Subject: RE: 19/02001/F - The Chaff Place, High St, Bodicote

I have reviewed Tom's response and the updated Transport Statement, DTA, dated 14th April 2020, and have visited the site on foot.

JOB TITLE		Bodicote, Banbury		CLIENT		Mr Alex Watson	
DRAWING TITLE							
Site Access Visibility Splays							
SCALE	DRAWN BY	DATE	DRAWING No	REVISION			
1/250@A3	JA	March2020	21487-03

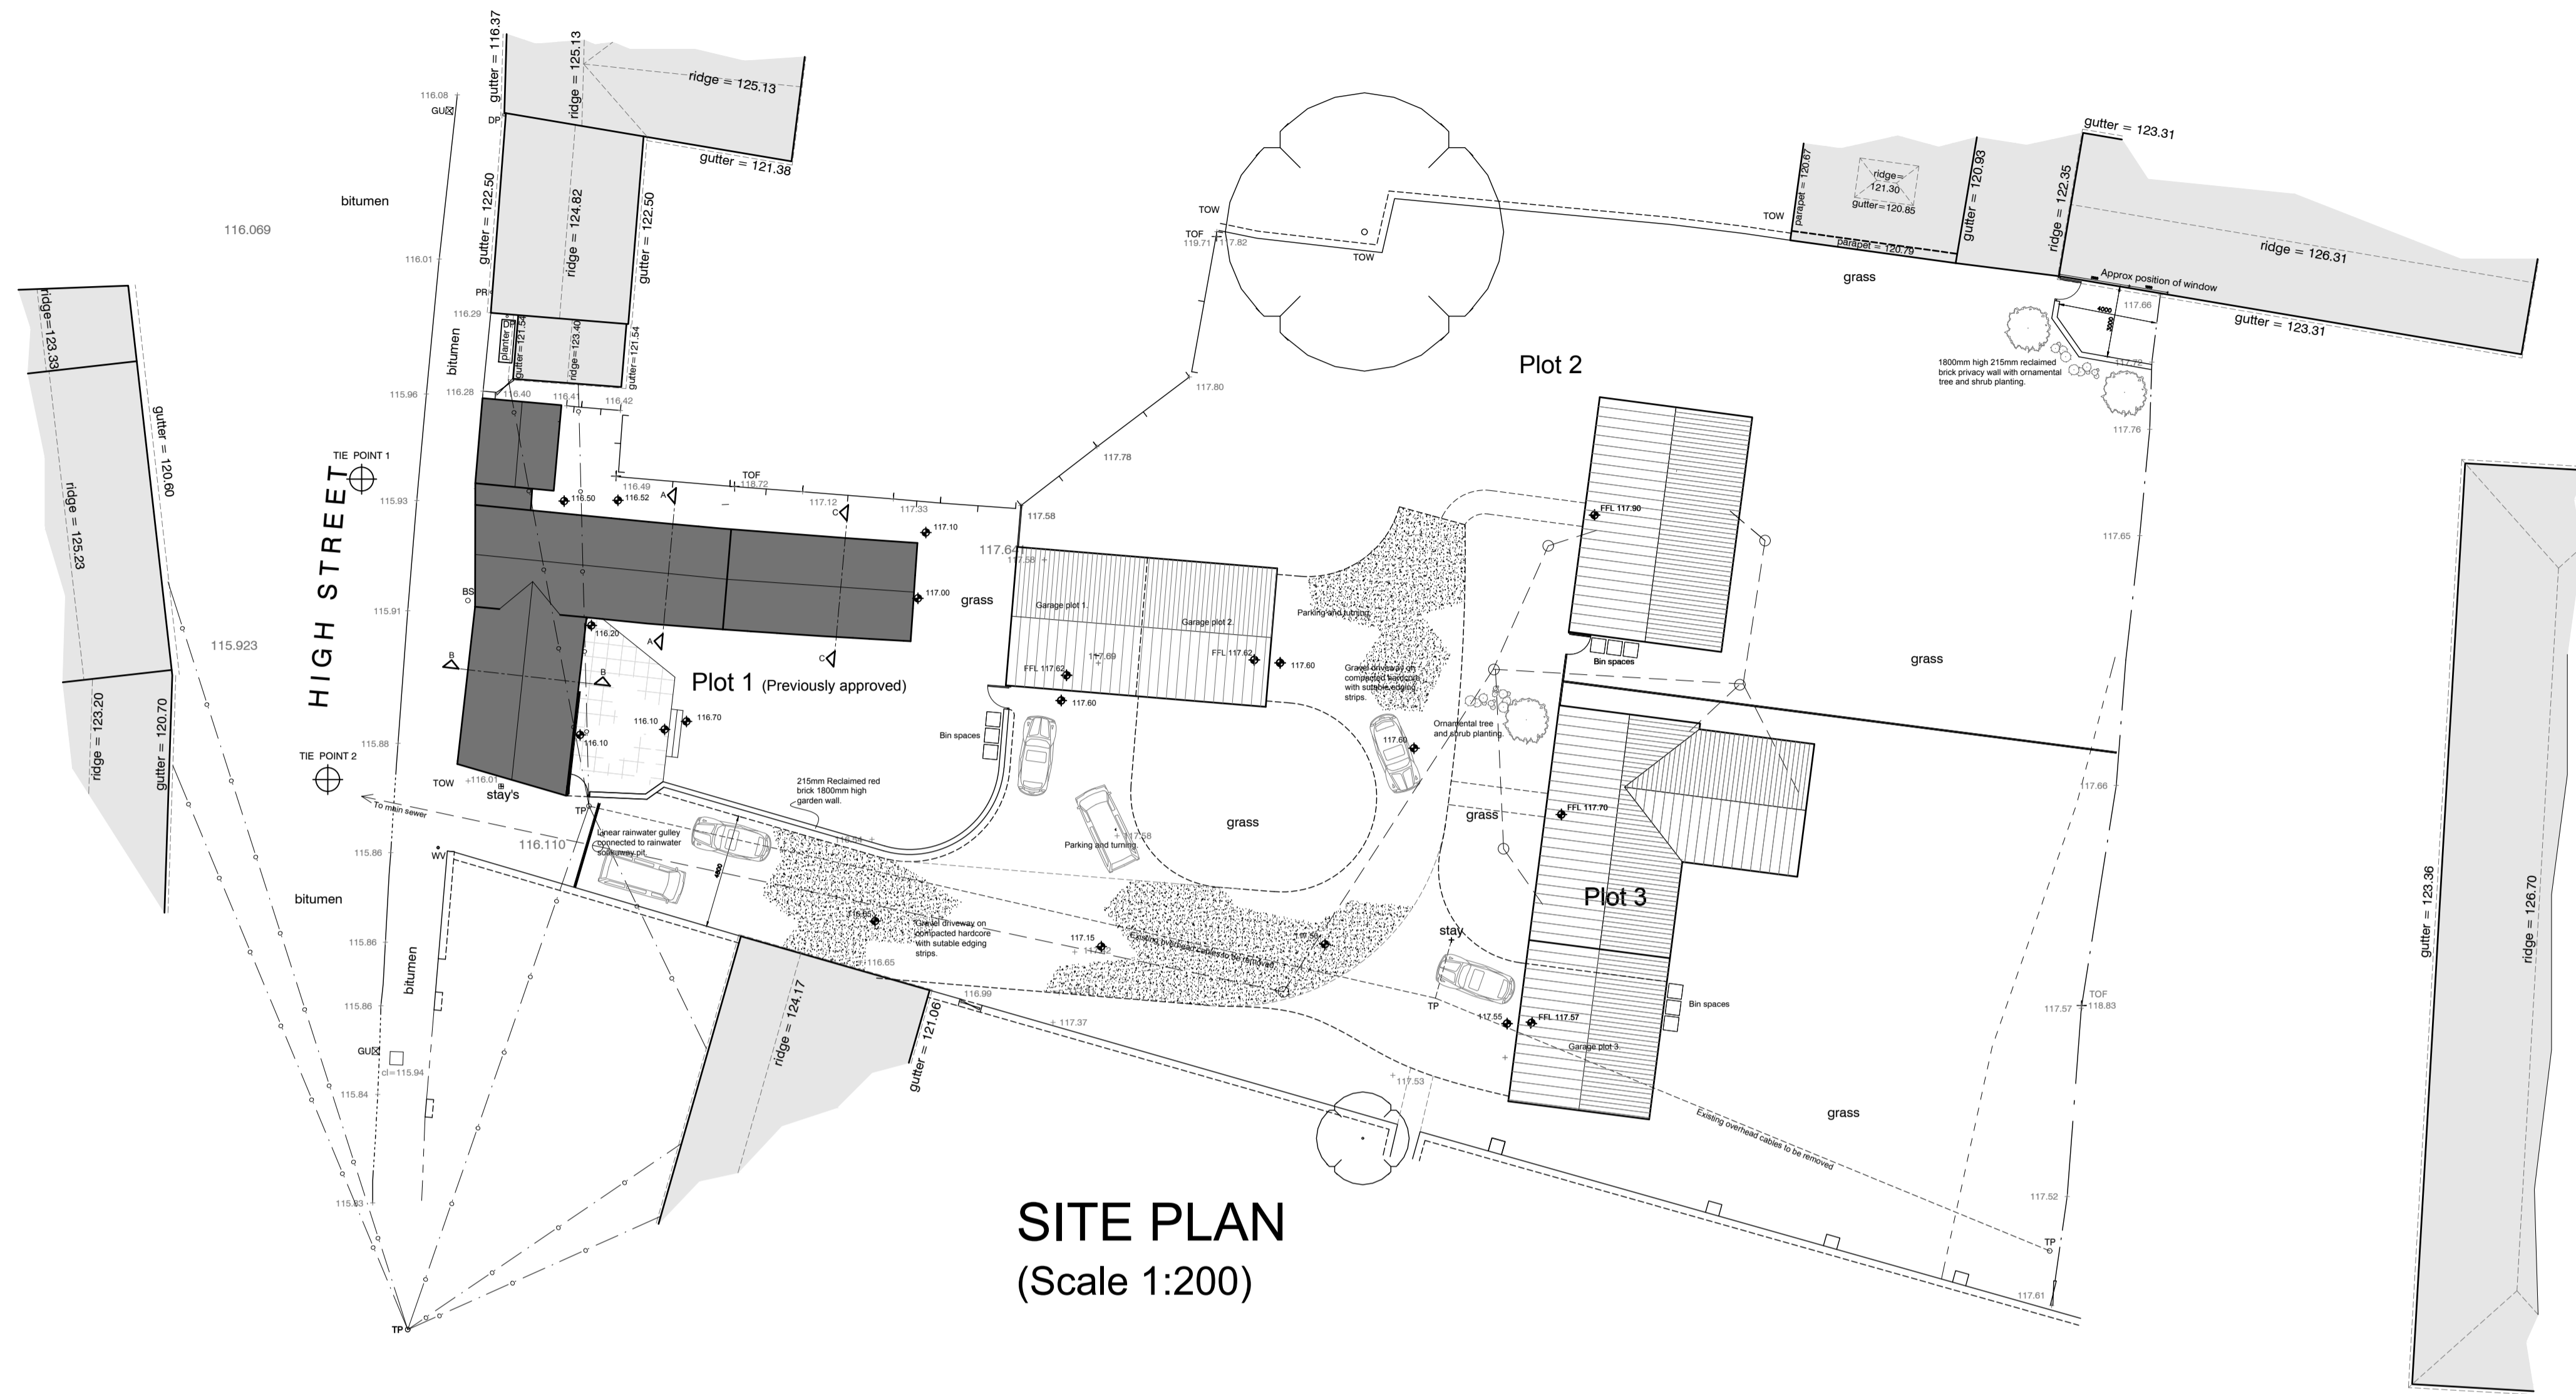
A speed survey has been carried out by the applicant and a drawing provided showing the achievable visibility splays at the junction. This demonstrates that visibility splays in accordance with Manual for Streets can be achieved, albeit they could have temporary obstructions caused by parked cars or stopped buses. However, on street parking as a temporary obstruction is normal and accepted within a built up area. Buses would be stopped for a very short time and drivers could wait for them to move on before exiting.

In light of the above I hereby remove the Highway Authority's objection to this planning application.

SITE PLAN
(Scale 1:200)

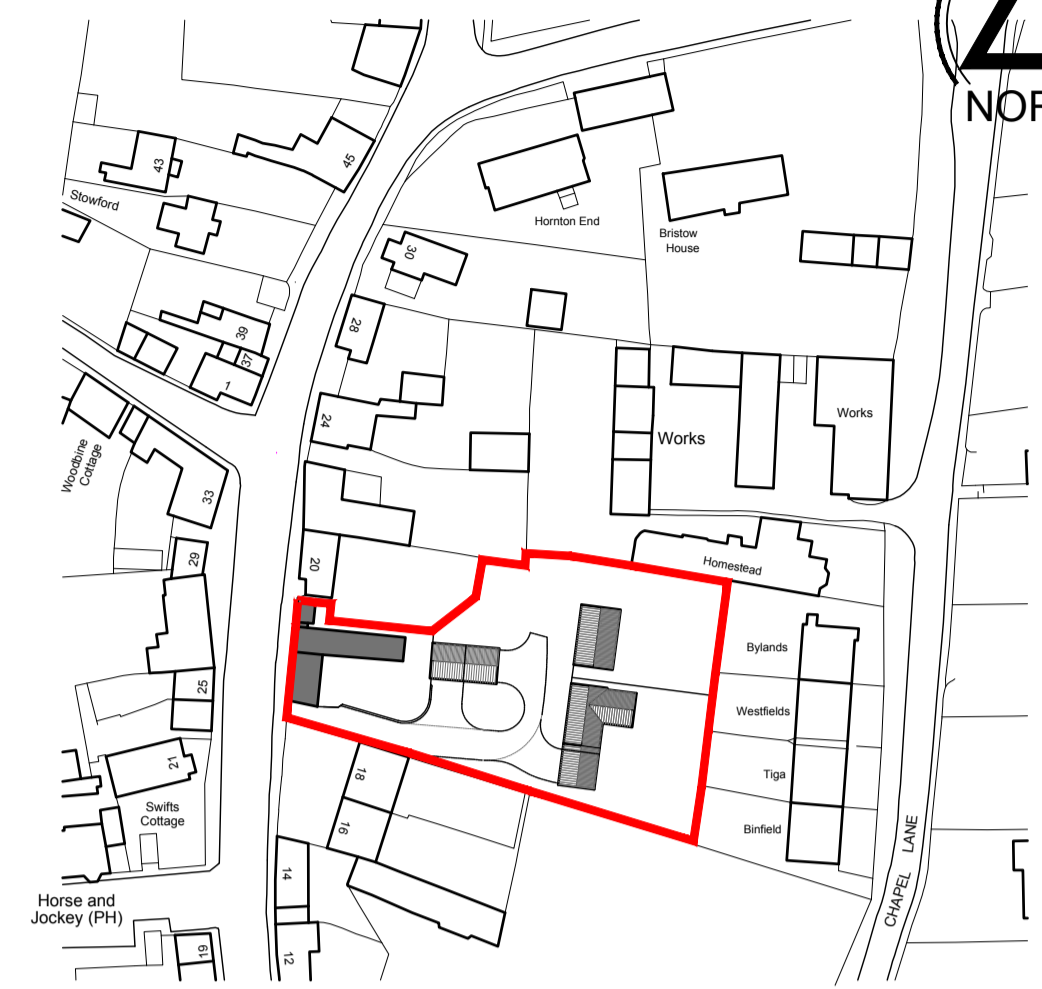
There does remain a slight risk of vehicles not being able to pass one another in the narrow entrance, but again, this is not unlike other accesses locally and in similar, village locations. It is most likely that the vehicle exiting would reverse within the site to allow the other vehicle to enter, and the site plan shows that this would not be too difficult.
